PROJECT DESCRIPTION: Divide one existing lot into two lots

PLANNING DEPARTMENT December 8, 2010 **DRB Comments**

PROJECT # 1005083

RE: Lot 11A, Block 2, Juan Tabo Addition

**PLAT OF
LOTS 11-A & 12-A, BLOCK 2
JUAN TABO ADDITION
SECTION 15, T. 10 N., R. 4 E., N.M.P.M.
CITY OF ALBUQUERQUE
BERNALILLO COUNTY, NEW MEXICO
NOVEMBER 2010
SHEET 1 OF 2**

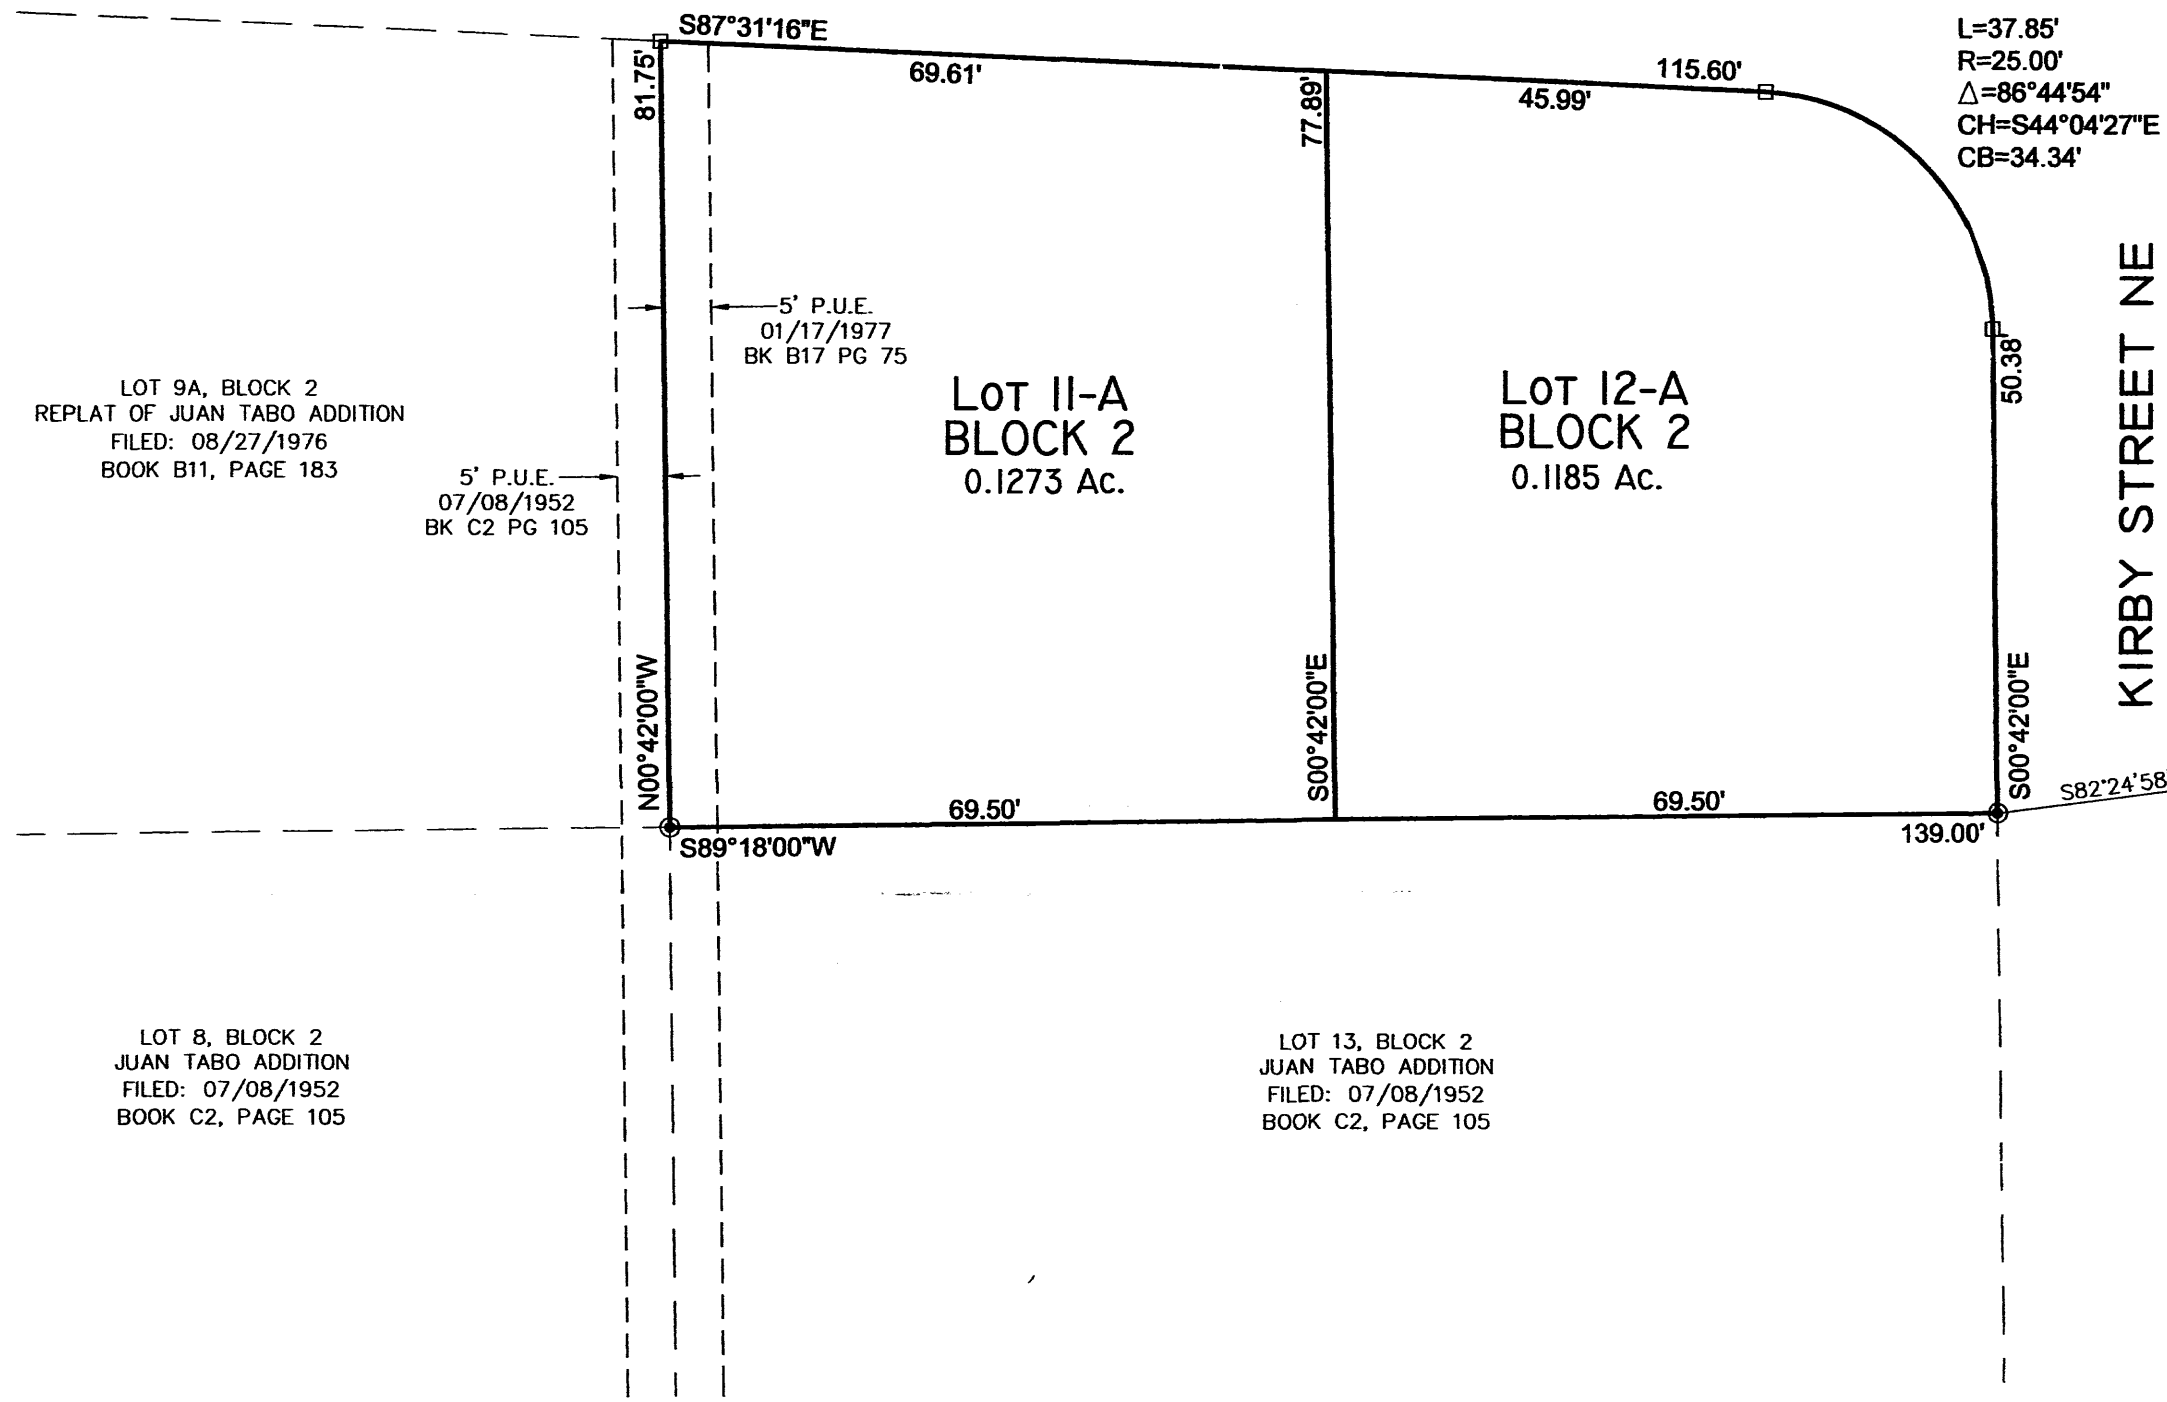
It appears a County Zone Atlas page is being used for the vicinity map this would be more legible with a City Zone Atlas page.
